From:
Sent: 27 June 2024 18:49
To: Nick Hirst
Cc: DCAdmin
Subject: Planning Application 2024-91236 - Another Contradiction Basements
Attachments: another_contradiction_basement.pdf

The applicant wants to build basements.

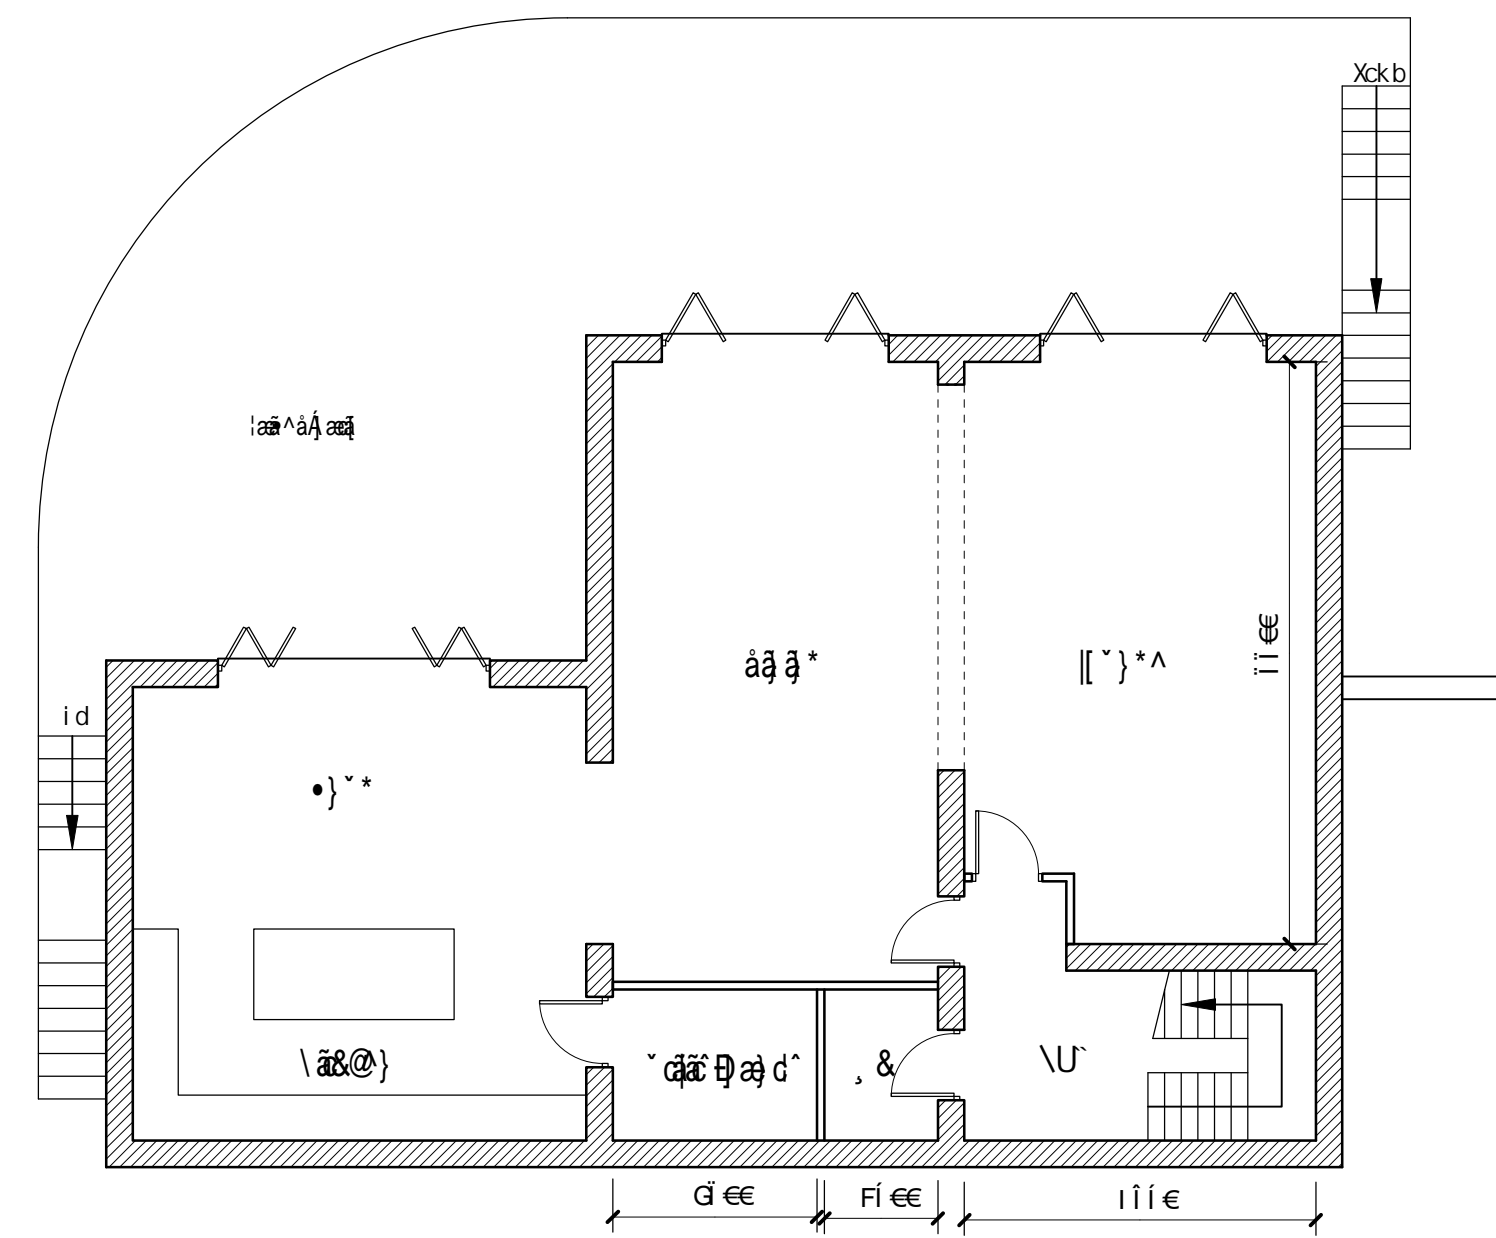
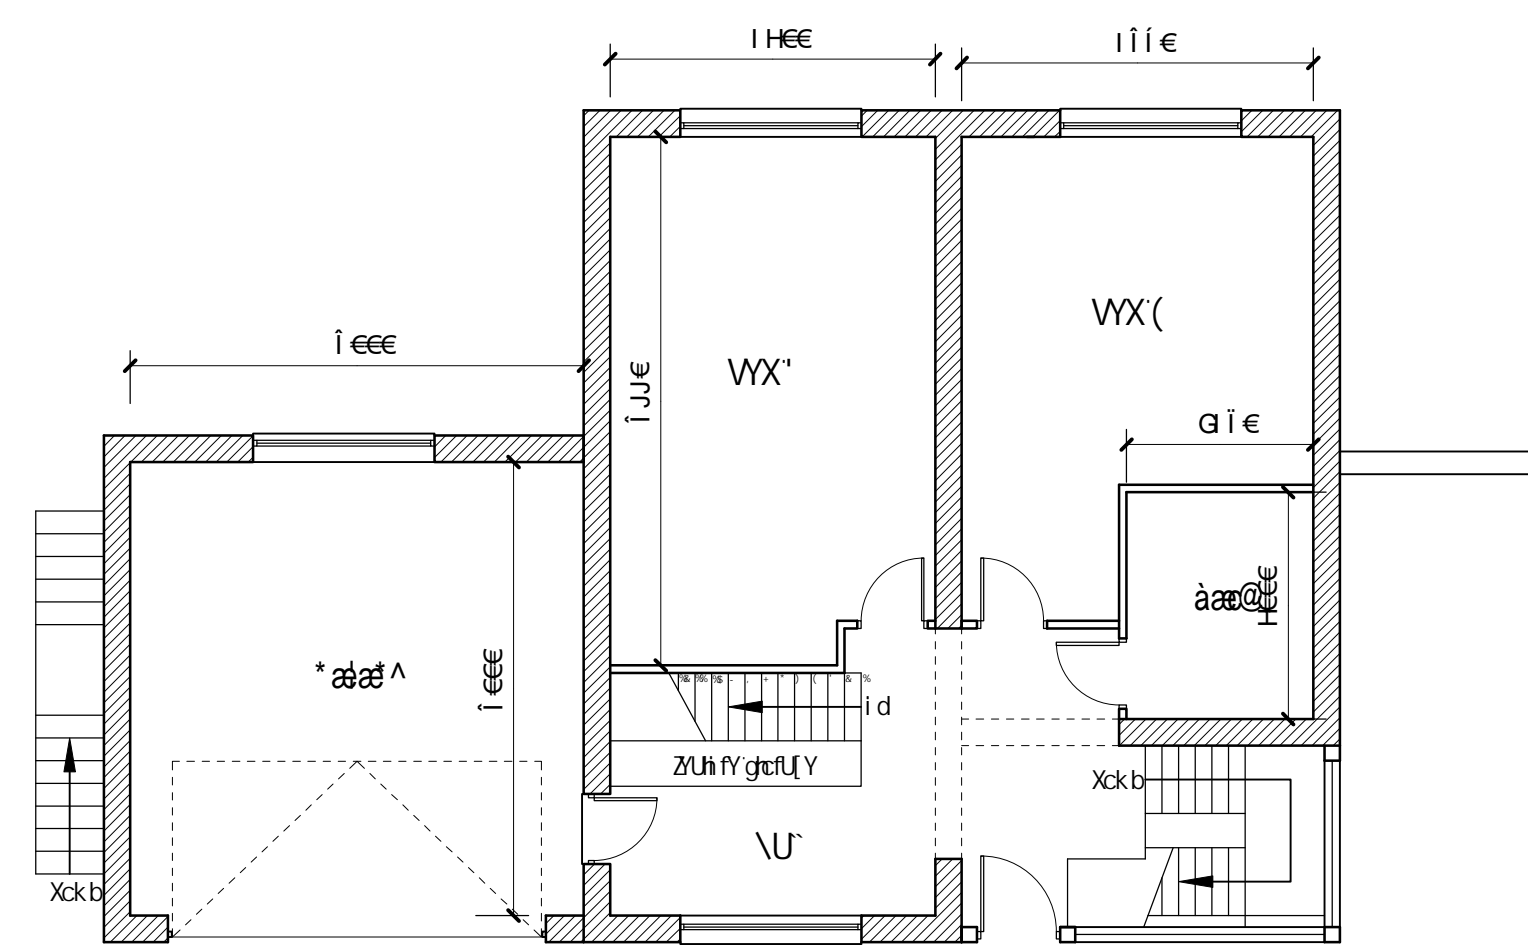
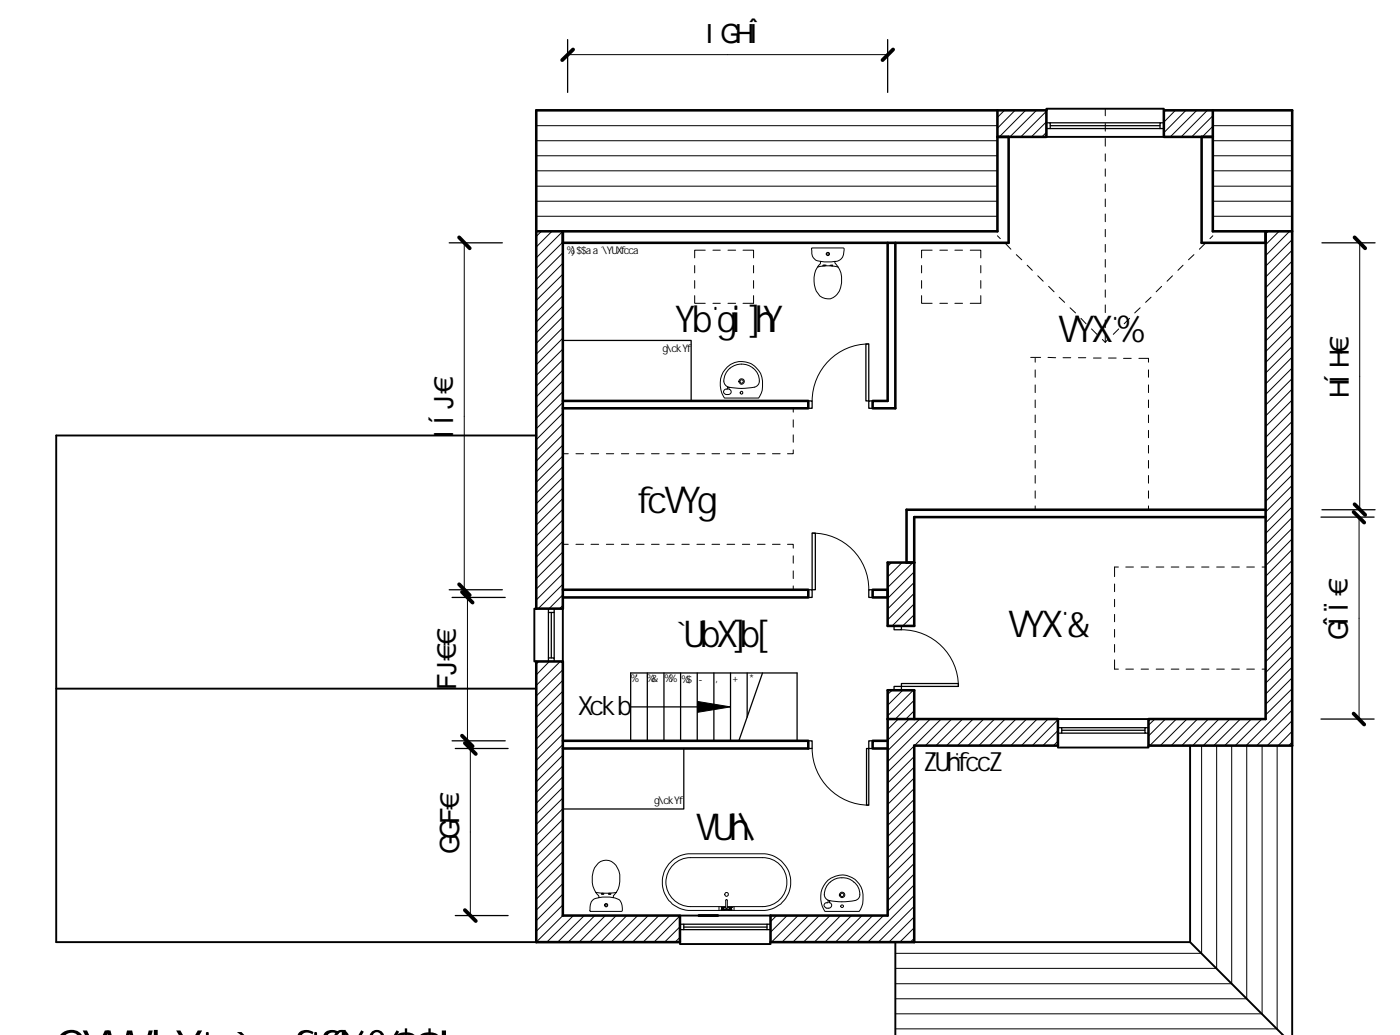
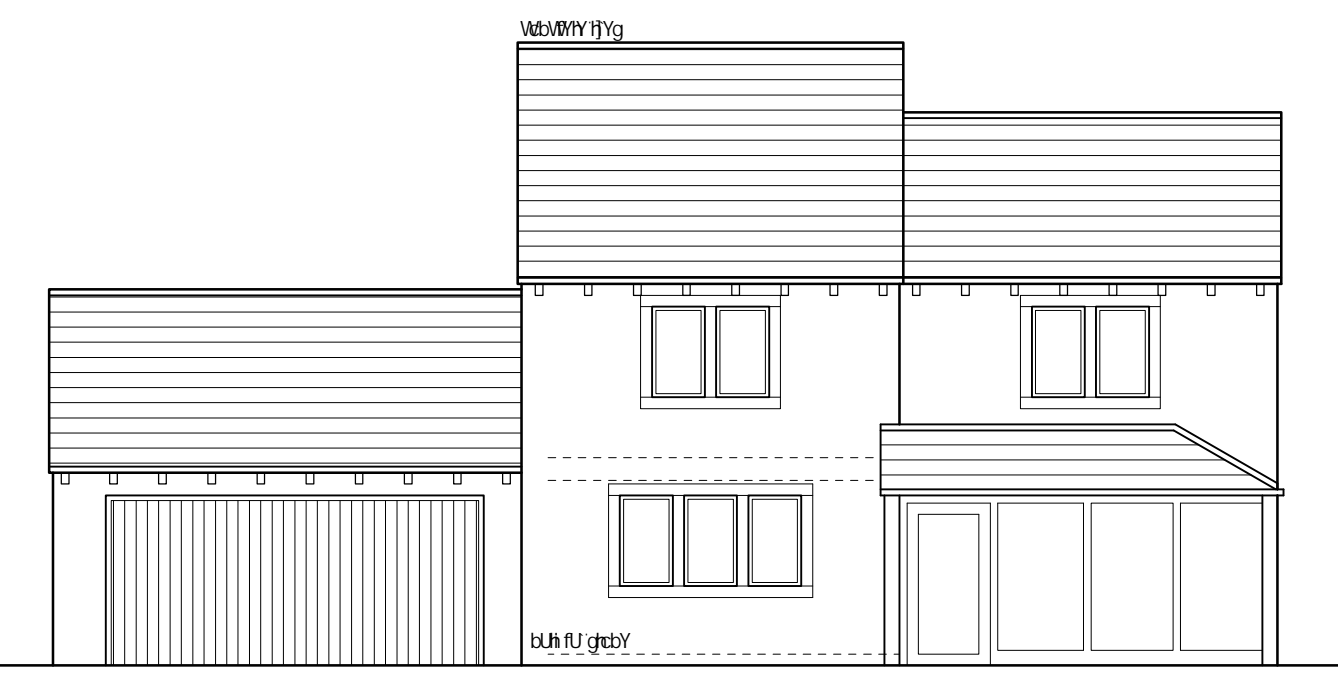
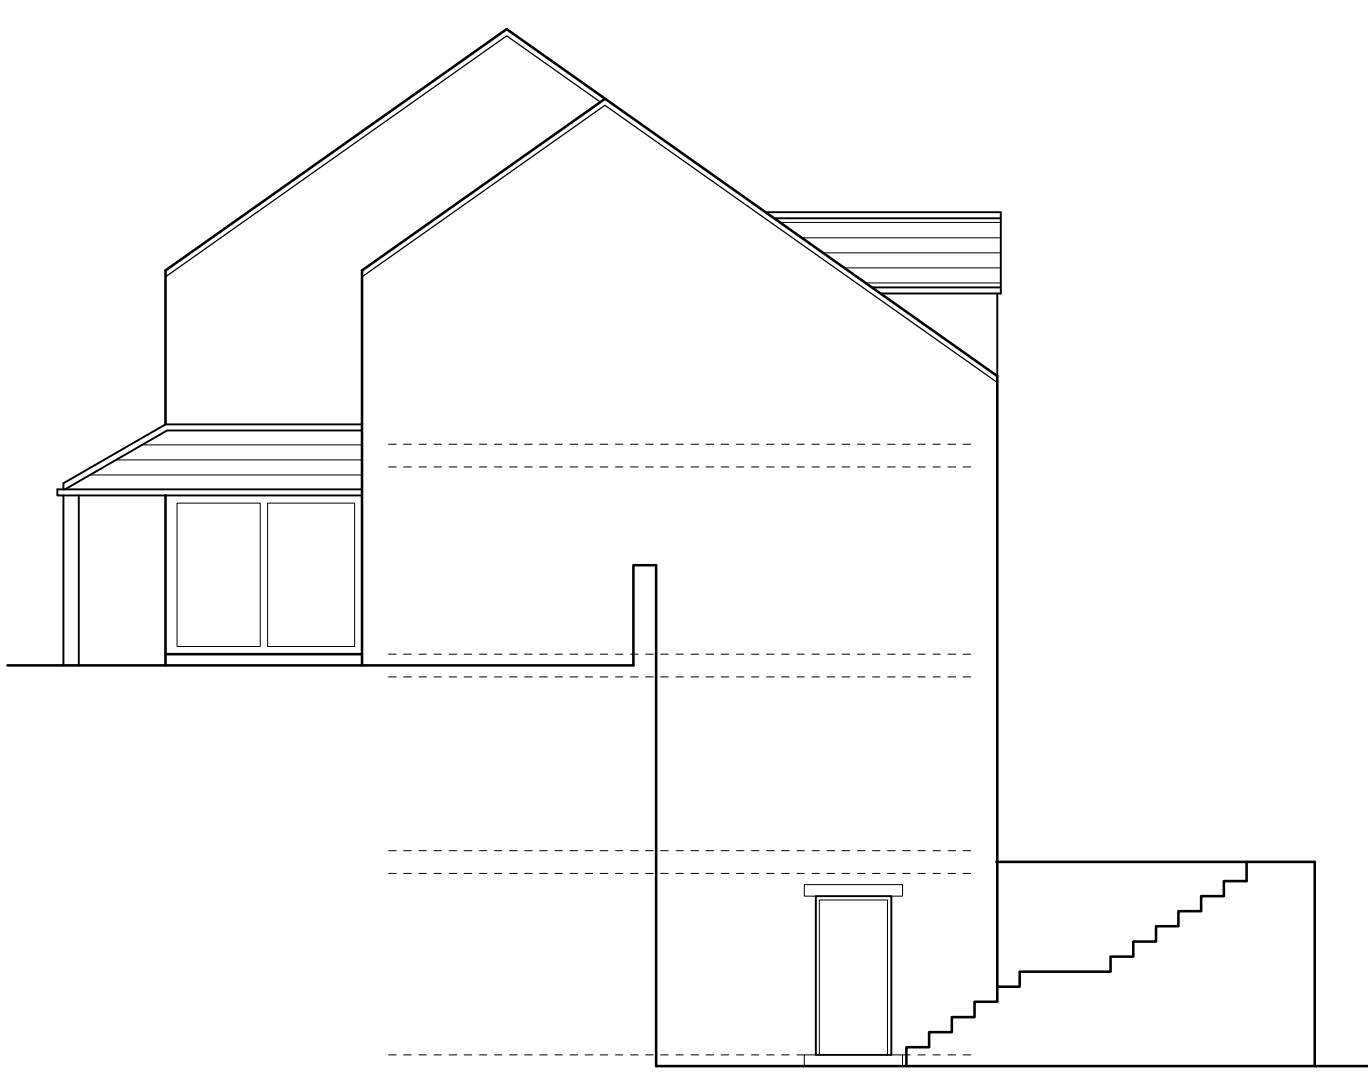
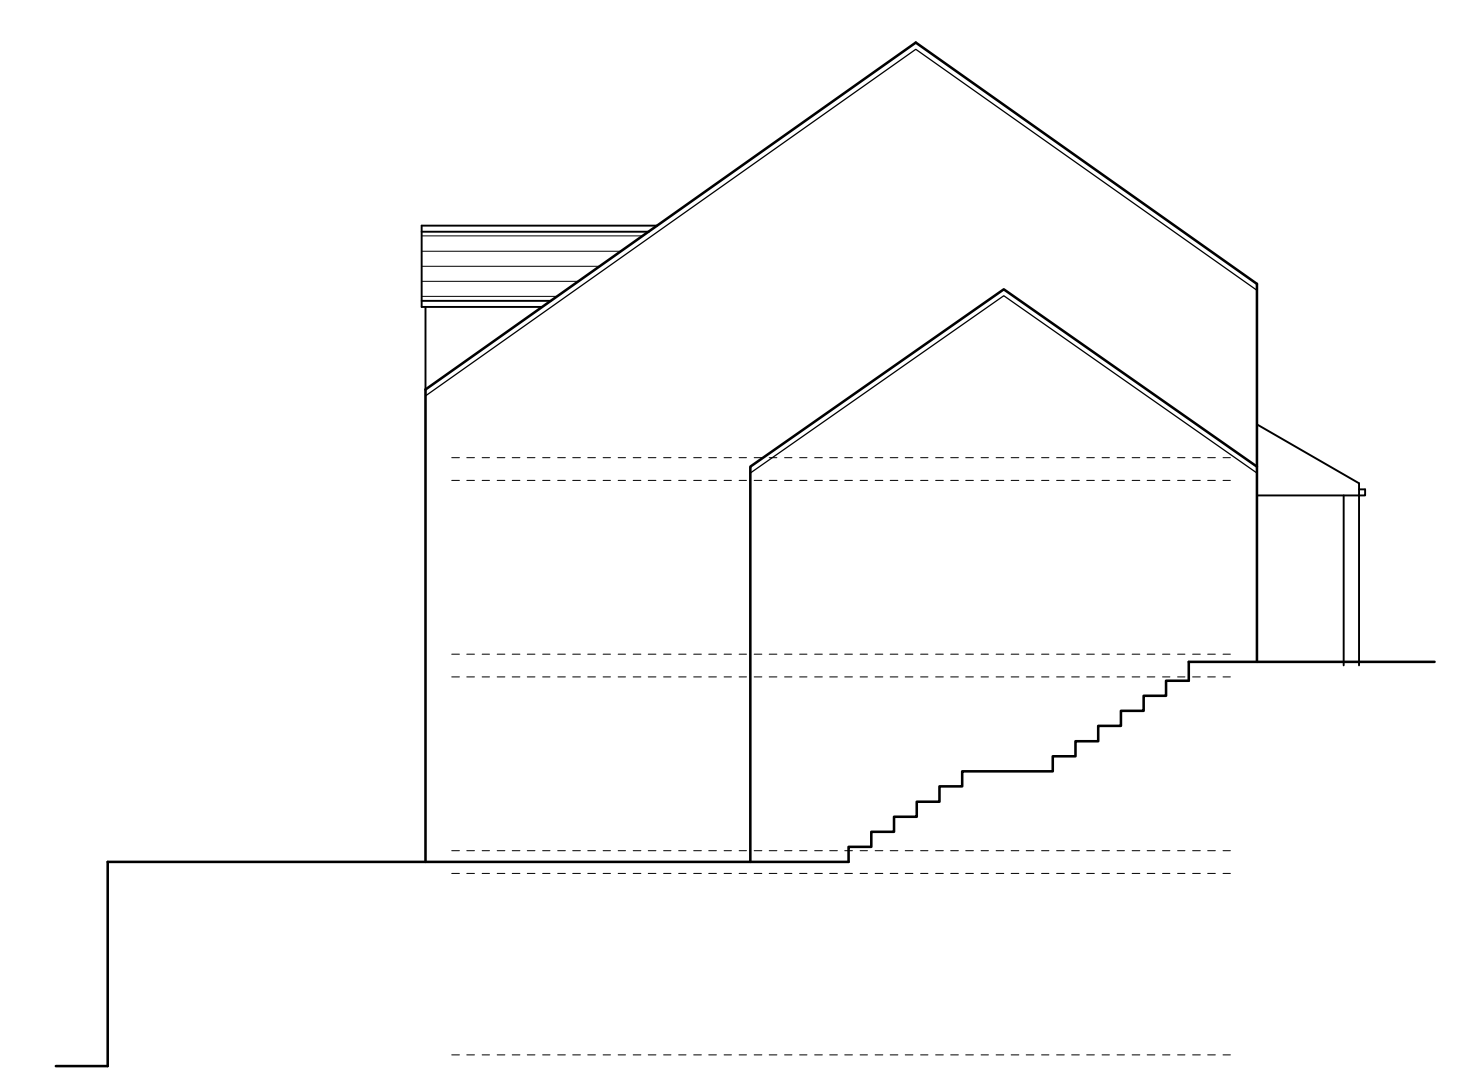
One observation that makes me question the applicant, concerns plot 23.

The kitchen and snug, at plot 23, would be under the garage.

But there would be no basement underneath the kitchen and snug, as there would be underneath the rest of the dwelling.

Perhaps, the basement is intended to be so extended, but the plans are incorrect.
